COUNTY COUNCIL'S RESPONSE TO CONSULTATION ON THE FOLLOWING DEVELOPMENT PROPOSAL

Application No: 18/00484/OUT

Proposal: Outline planning permission for up to 75 homes, pedestrian and cycle routes, creation of new access point from Charlotte Avenue, provision of open space, play space, allotments, orchard, parking and associated works.

Location: Land North and Adjoining Home Farm Banbury Road B4100 Caversfield

Fig 5.1 - Access and Movement Parameter Plan

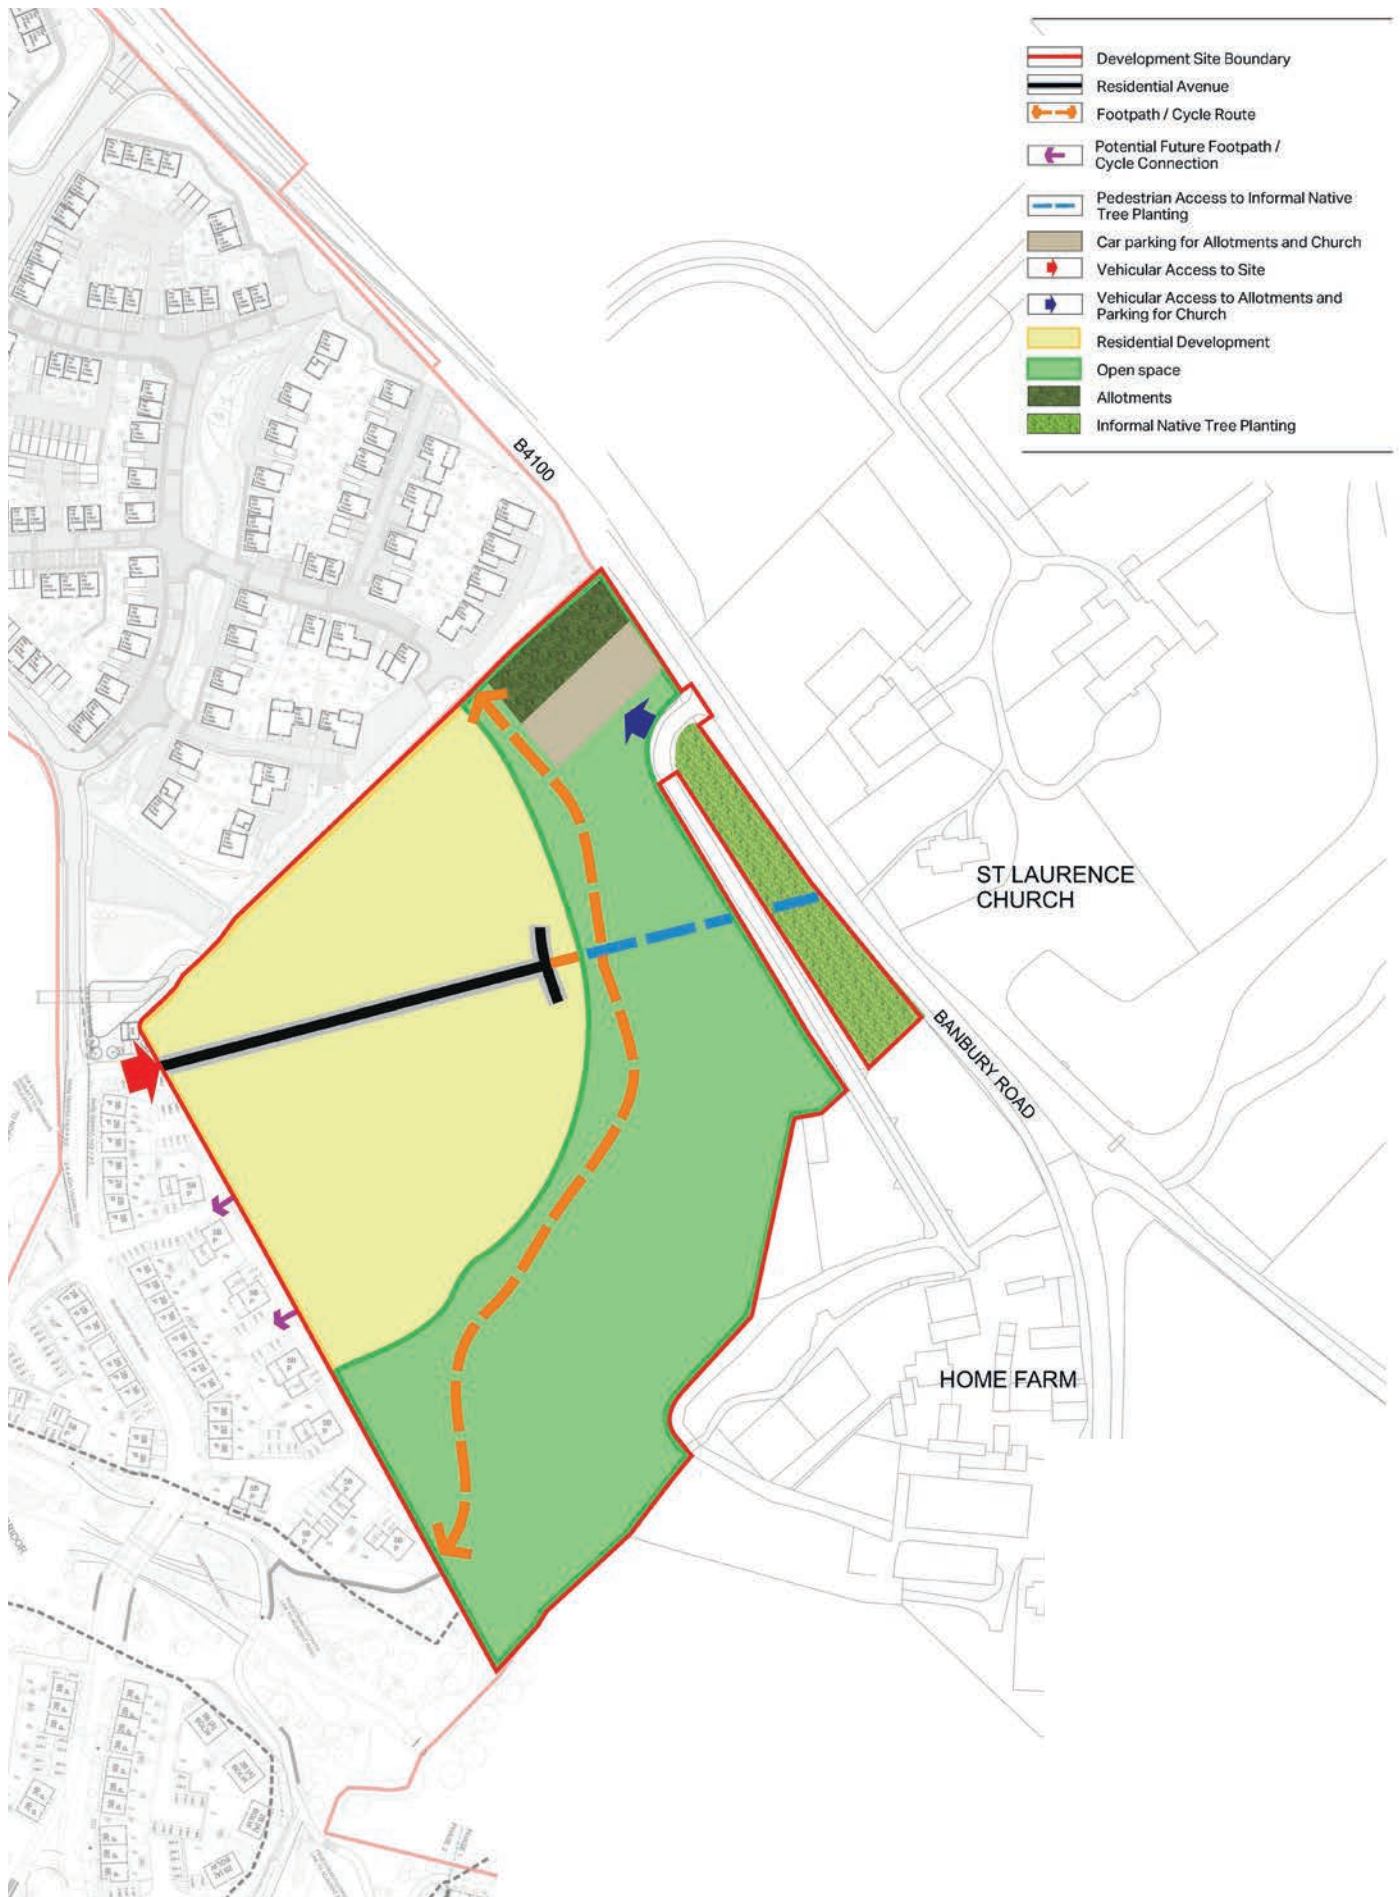
Only two pedestrian connection points to adjacent parcels are proposed. This represents a missed opportunity for a level of permeability which is in keeping with the sustainable travel policy requirements of the Eco Town, and should be addressed by including additional connection points. Connection points towards the current bus stops are particularly important to look at, to ensure all properties are within a 400m walk of the bus stops. Such connection points should not be left to reserved matters stage but included on the access parameter plan in order to ensure that they are secured. **Reason for objection.**
